**SITE PLAN CONTROL APPLICATION
DELEGATED AUTHORITY REPORT
PLANNING, DEVELOPMENT AND BUILDING SERVICES DEPARTMENT**

Site Location: 2750 & 2760 Sheffield Road, 2713 Lancaster Road 2865 F Walkley Road and Two Unaddressed Parcels

File No.: D07-12-24-0156

This SITE PLAN CONTROL application submitted by Dani Farah, on behalf of Richcraft Homes Ltd., is APPROVED upon resolution of the conditions stated in this report

Title
STORM DRAINAGE PLAN

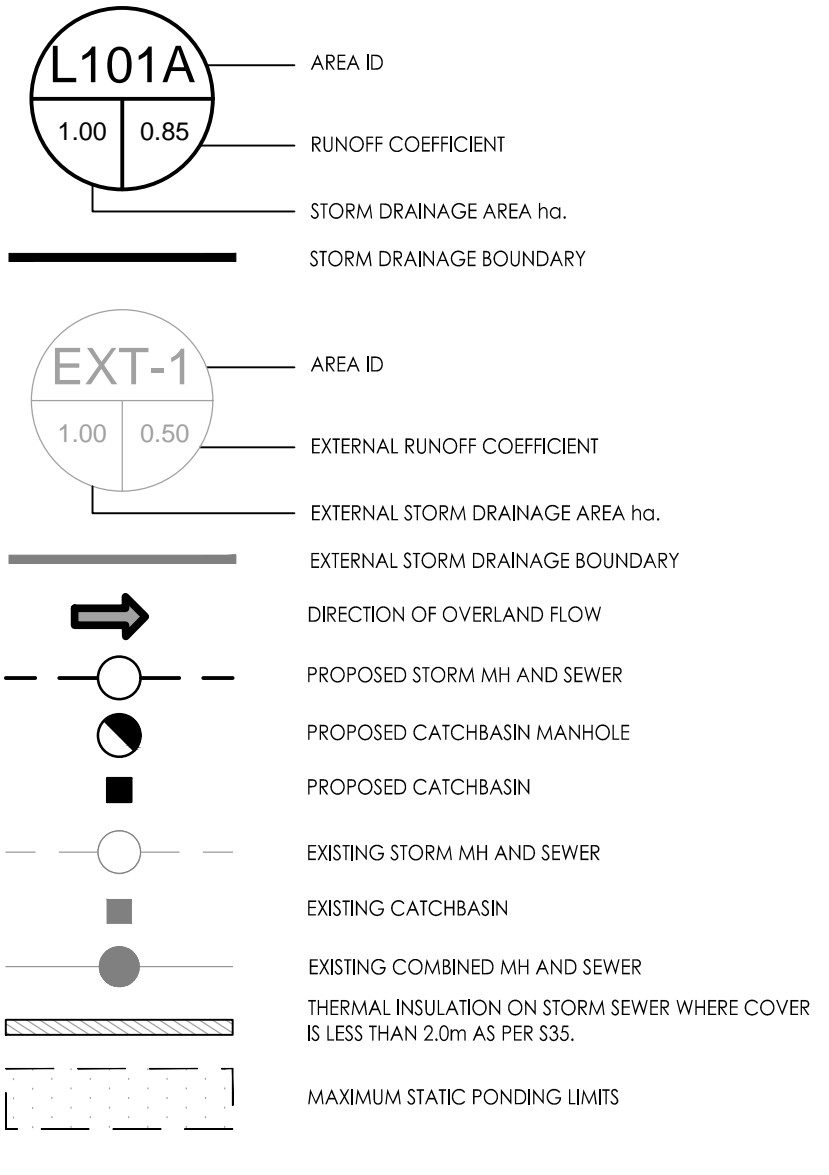
The Owner acknowledges and agrees, prior to the preparation of the Site Plan Agreement or issuance of a Commence Work Notification, to update the civil plans and Site Servicing Plan such as the stormtech chamber is lined with an impermeable liner, to the satisfaction of the General Manager, Planning, Development and Building Services Department. The Owner further acknowledges and agrees that the submission may necessitate changes to the plans and reports approved herein. If necessary, the Owner further acknowledges and agrees to provide all revised plans and reports to the General Manager, Planning, Development and Building Services Department prior to preparation of the Site Plan Agreement or the issuance of a Commence Work Notification.

- Staff included conditions of approval to address outstanding comments that were not resolved during the formal review. Condition 2 requires an updated Site Servicing Plan showing a stormtech chamber that is lined with an impermeable liner as noted in the Geotechnical Report. This update is required to ensure that additional groundwater does not discharge to the surcharged municipal system. The applicant will also update the other civil plans accordingly, including the erosion control plan, grading plan, sanitary drainage plan and stormwater drainage plan.
